DEPARTMENT OF PLANNING

SUBJECT: COLLEGE OF FINE ARTS MP08 0104 MOD 2

To determine a modification request for the College of Fine Arts Campus (COFA), Paddington, Project Application (MP 08_0104)

project	COFA Gateway
drawing	SOUTH & NORTH ELEVATIONS (BLOCK D)
drawing no.	issue
	A2-03
	C

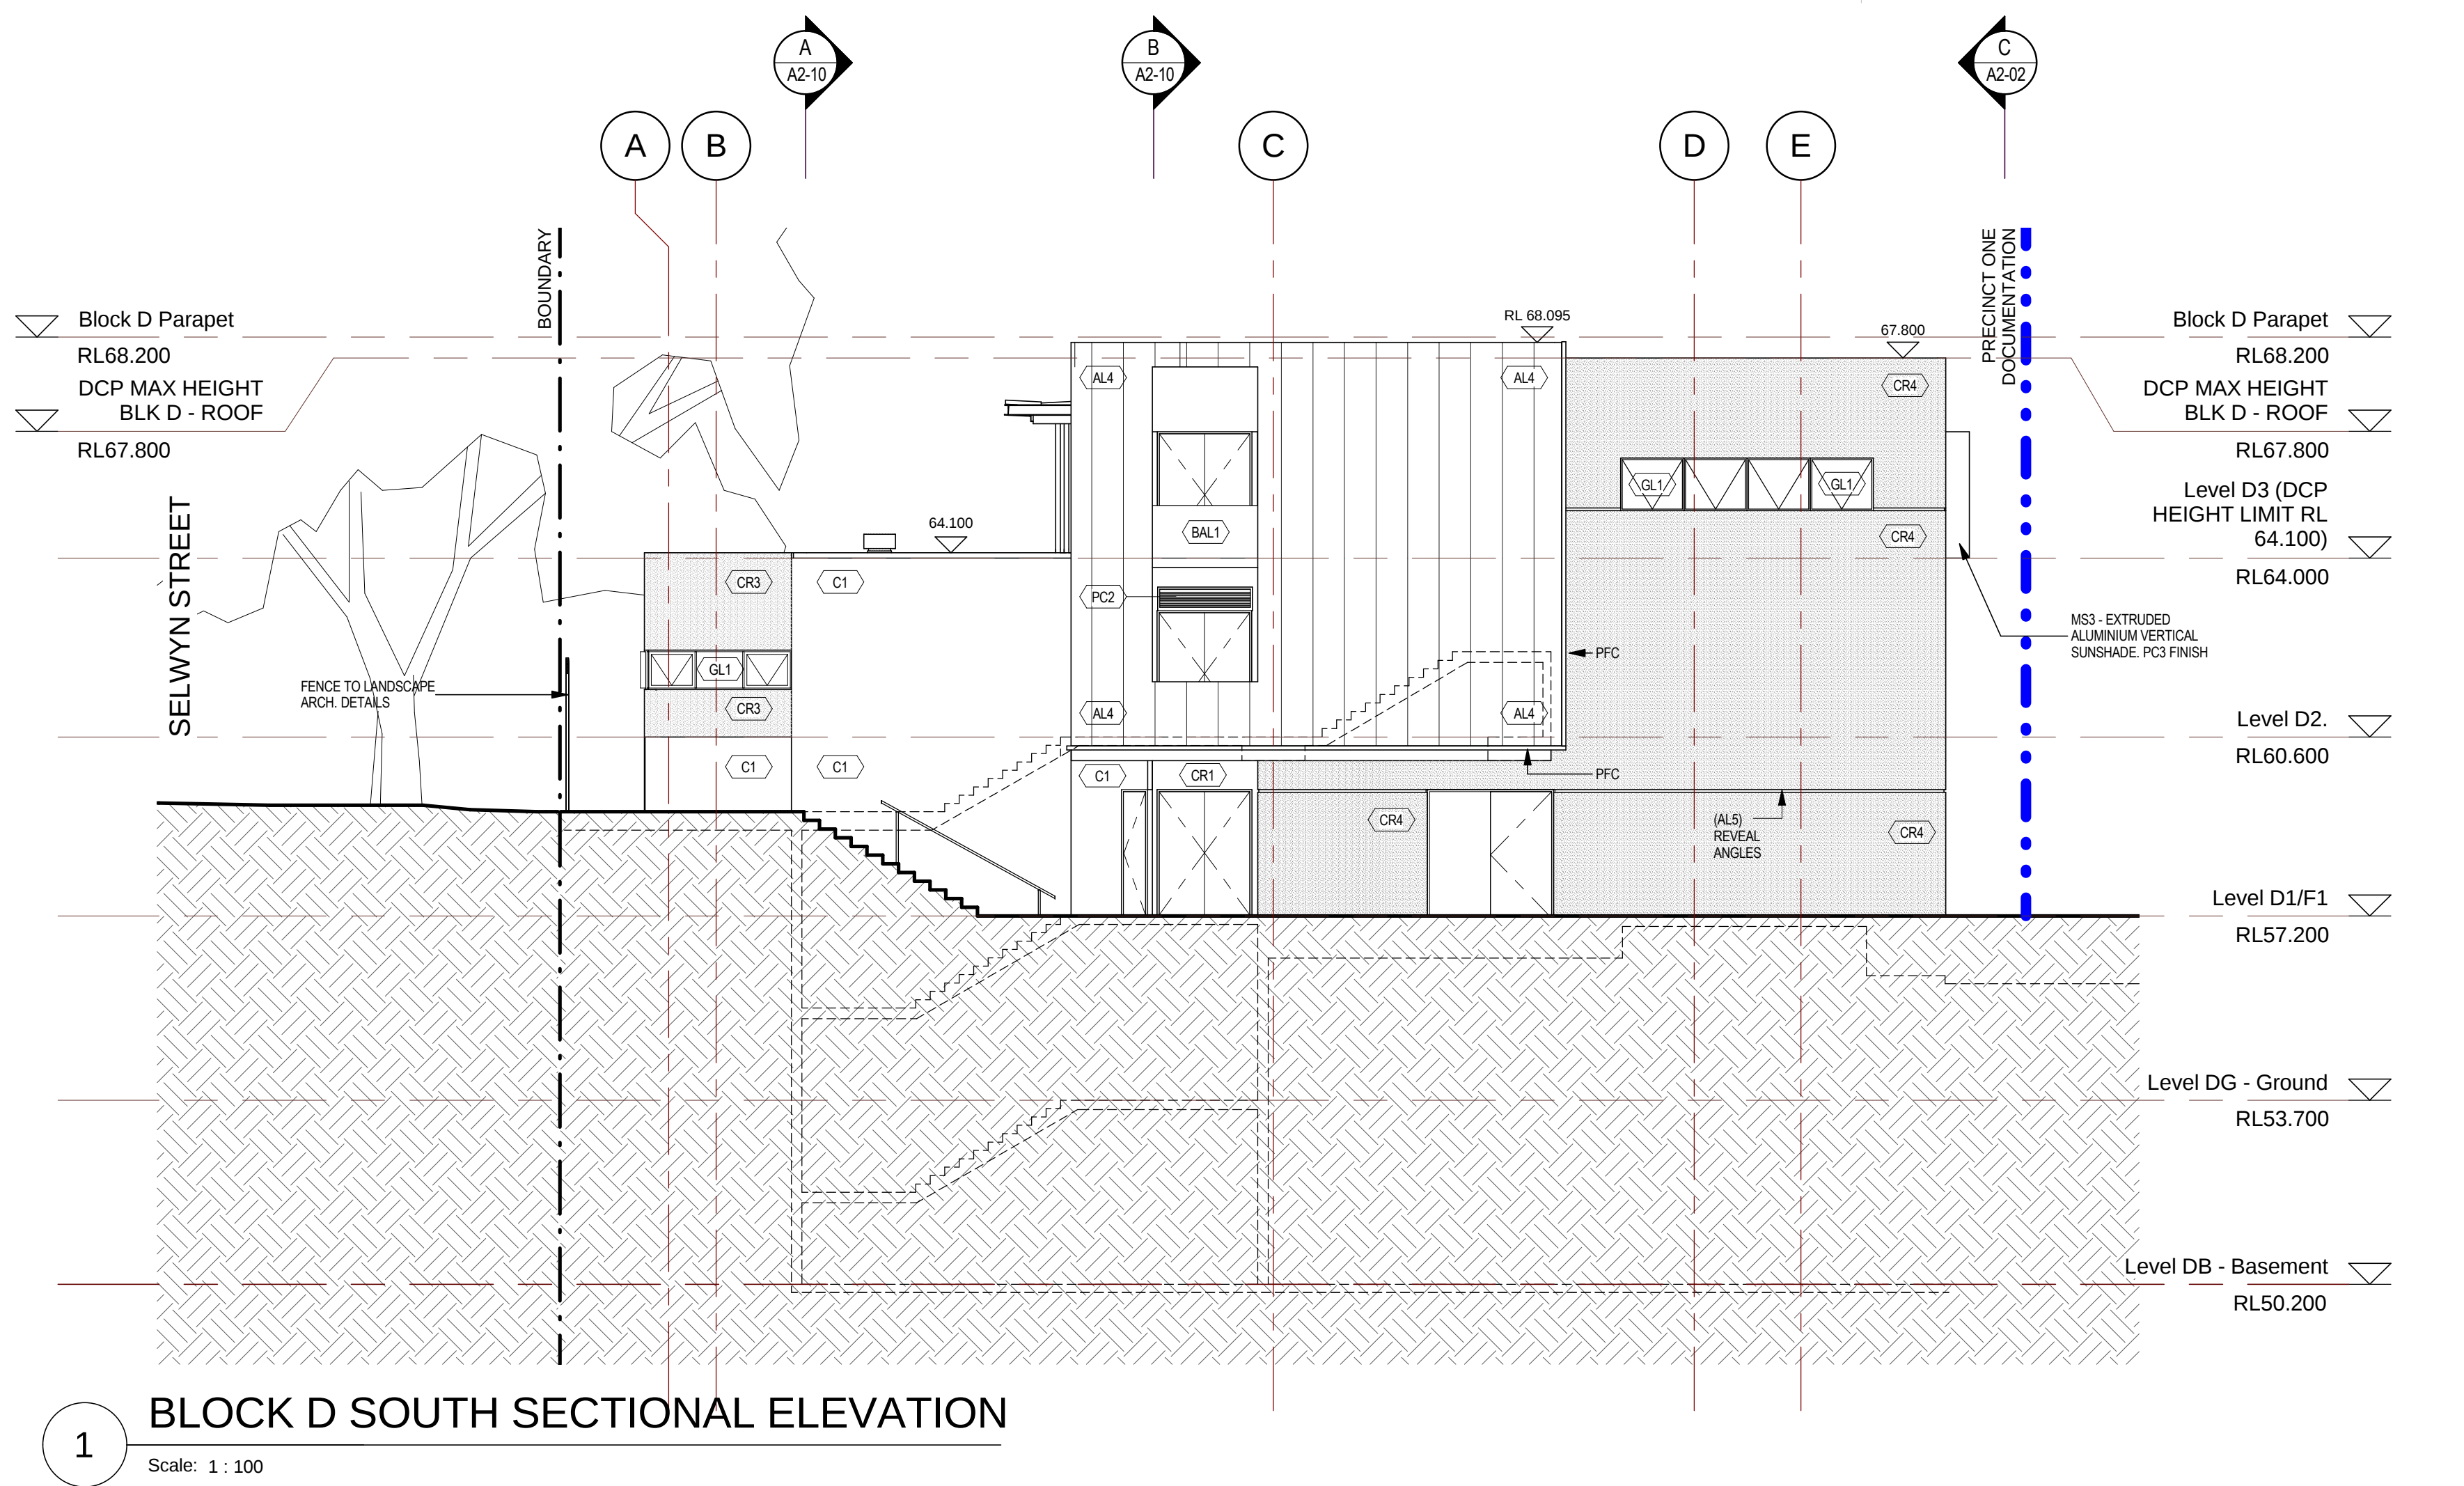
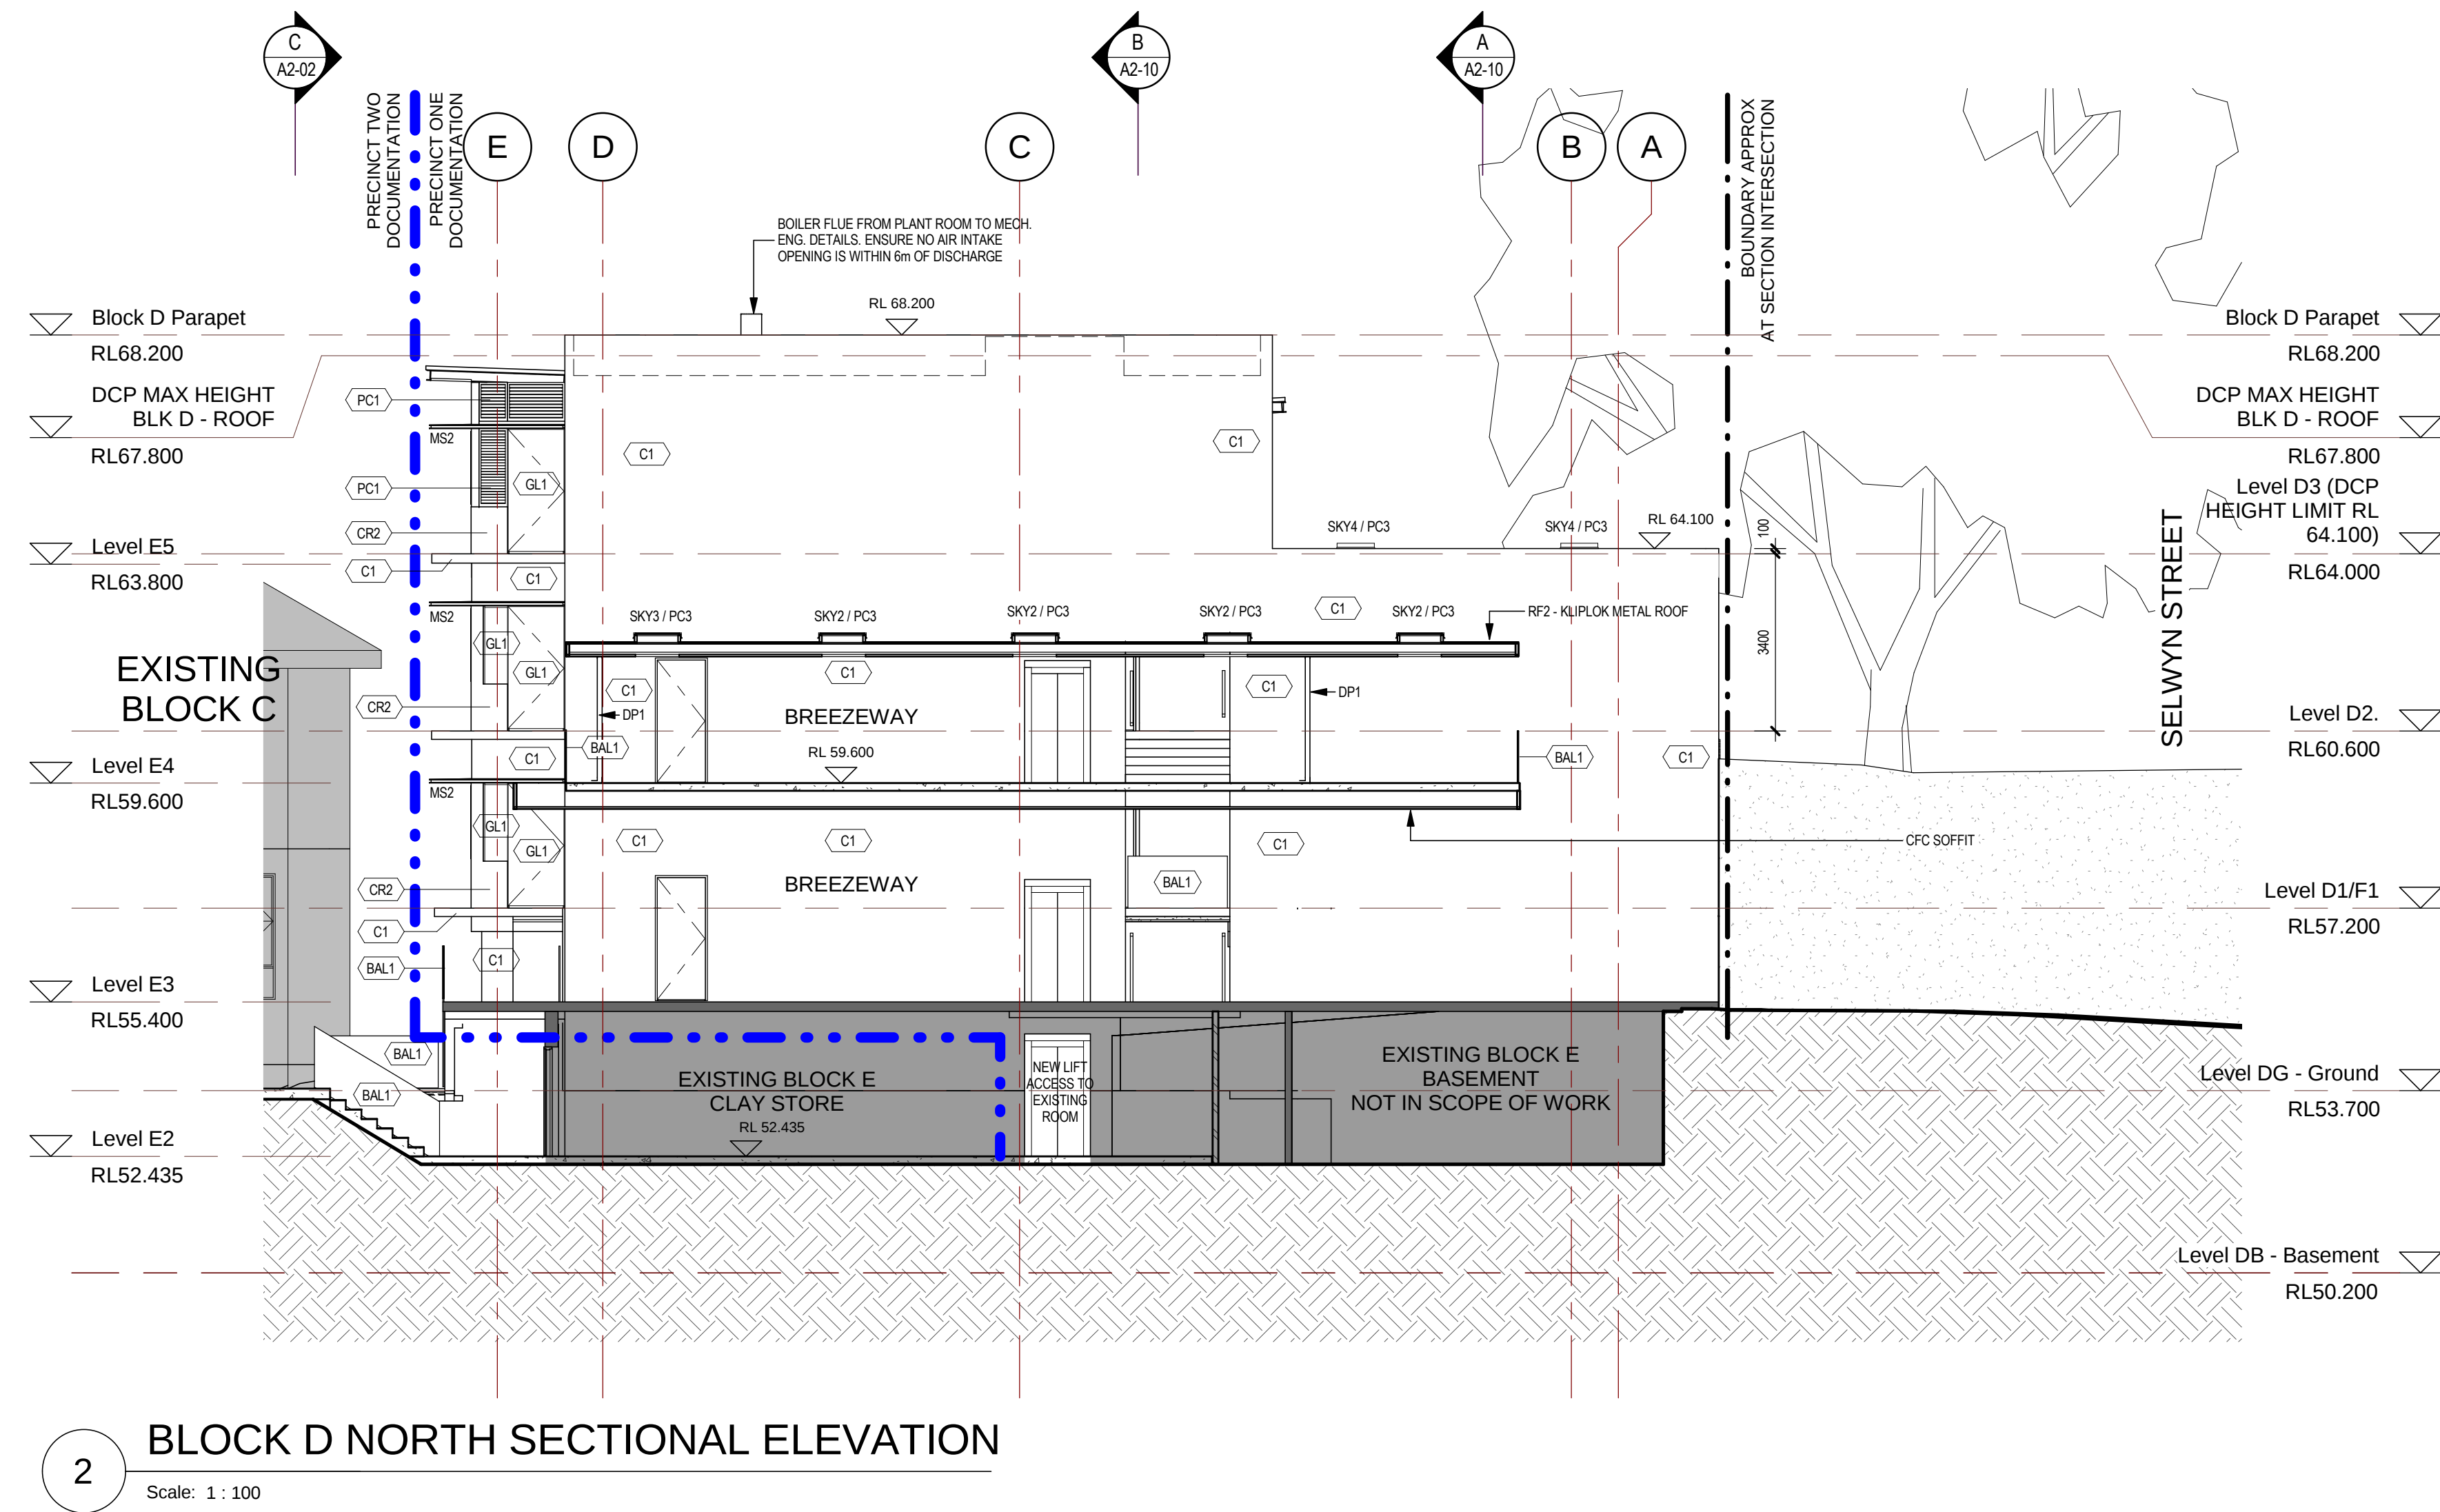
- Flat roofs over side cores marginally raised to accommodate lift overruns, addition of roof penetrations on drawings, materials and finishes changes and internal fit-out of Block D.

Setting the building back from the boundary will both further protect the existing street trees and decrease the shadow impact in Selwyn Street. This provides more setback than that provided for in the DCP. The marginal (400mm) increase above the height limit of the two lift cores at either end of the building does not increase overshadowing in Selwyn Street, nor create any other adverse impacts on the site or surrounding environment.
